From: [Alan and Pamela Walton](#)
To: [Murphy, Alexander N: a303sparkfordtoilchester@pins.gsi.gov.uk](#)
Subject: Re: 8.18 Mr and Mrs Alan Walton SoCG - TR010036 Long Hazel Park Reference 20014098
Date: 07 June 2019 13:22:43

Noise Modelling Methodology

General Proposed Hazlegrove Junction Layout

Drawing Title
**FIGURE 11.5
NOISE LEVELS IN THE DO SOMETHING OPENING
YEAR LA10, 18HR [dB] - SHEET 1 OF 4**

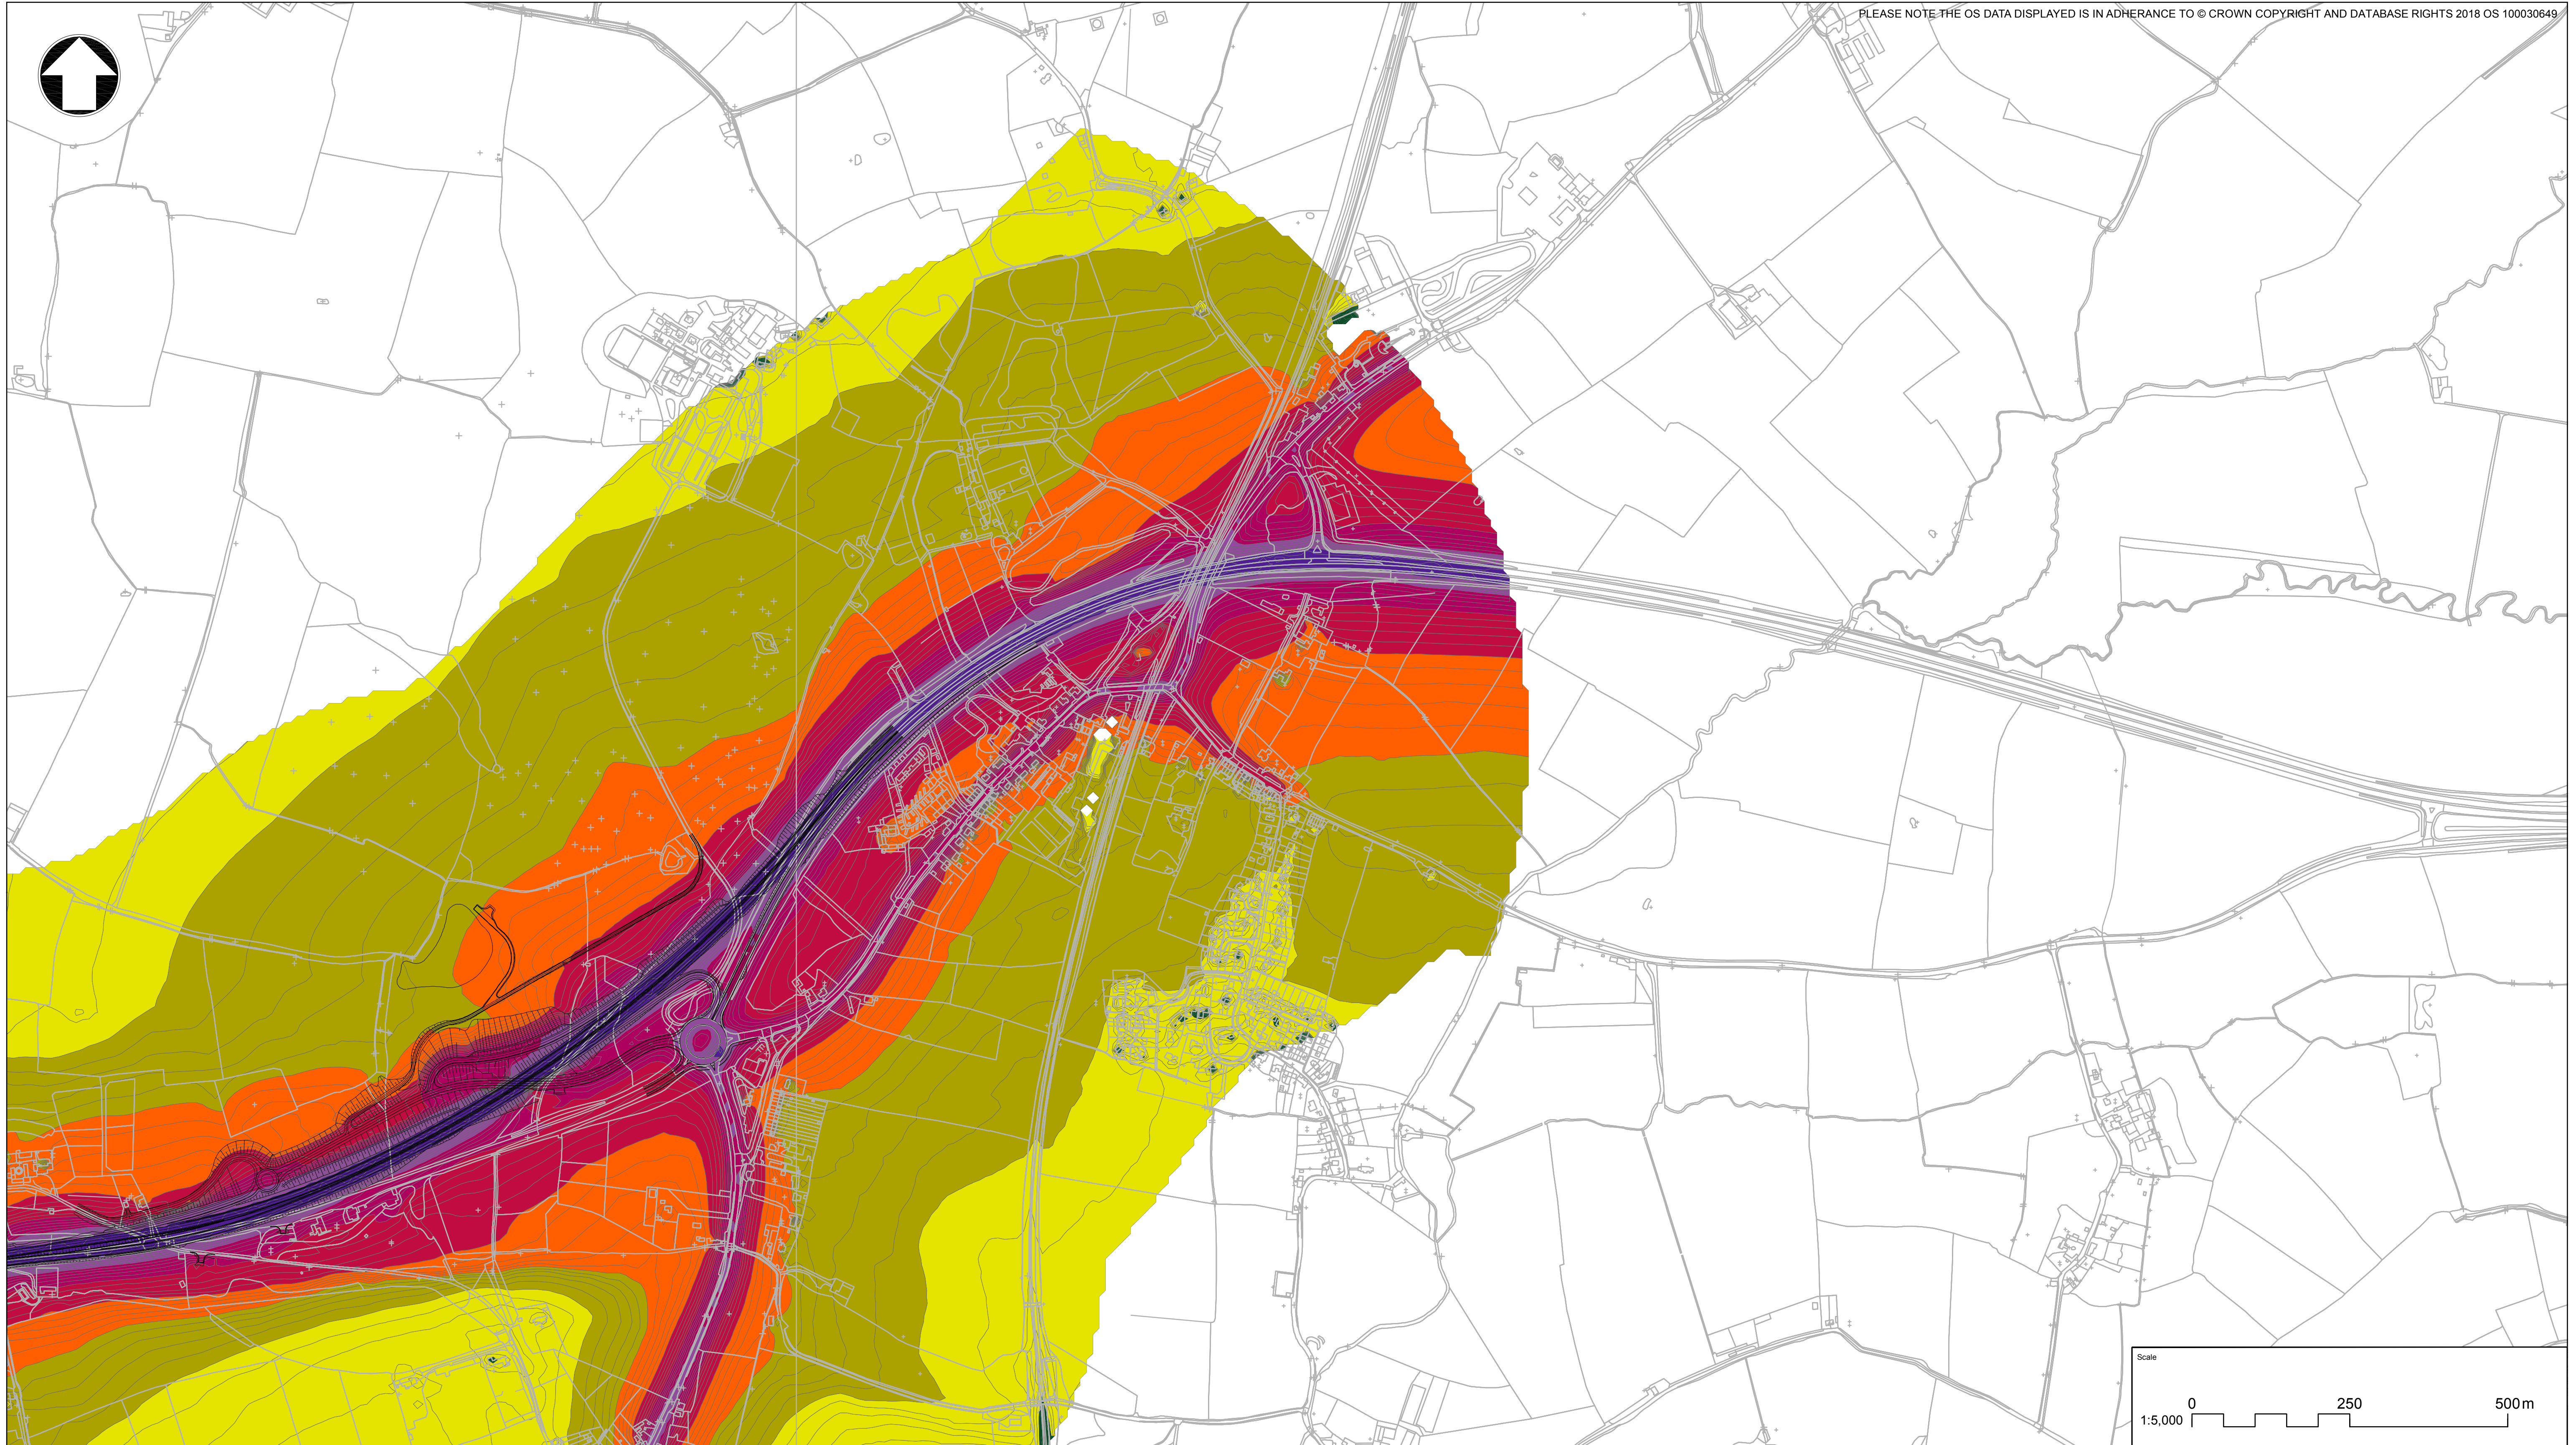
Long Hazel Park is downwind and is in line from the proposed elevated section of the dual carriageway. Noise barriers on either side of the carriageway will do little to mitigate the noise as the wind blows the increased noise in to Long Hazel Park and the surrounding area of the village. This section of road will be four lanes with a 70 mph speed limit. Currently it is two lanes with a 50 mph speed limit but as traffic merges on to the westbound carriageway the speed is often slower than 50 mph. The prevailing wind is from the west or southwest with speeds of up to 60 mph during weather storms especially in the winter when foliage has dropped from the trees. The Model does not take these factors into consideration.
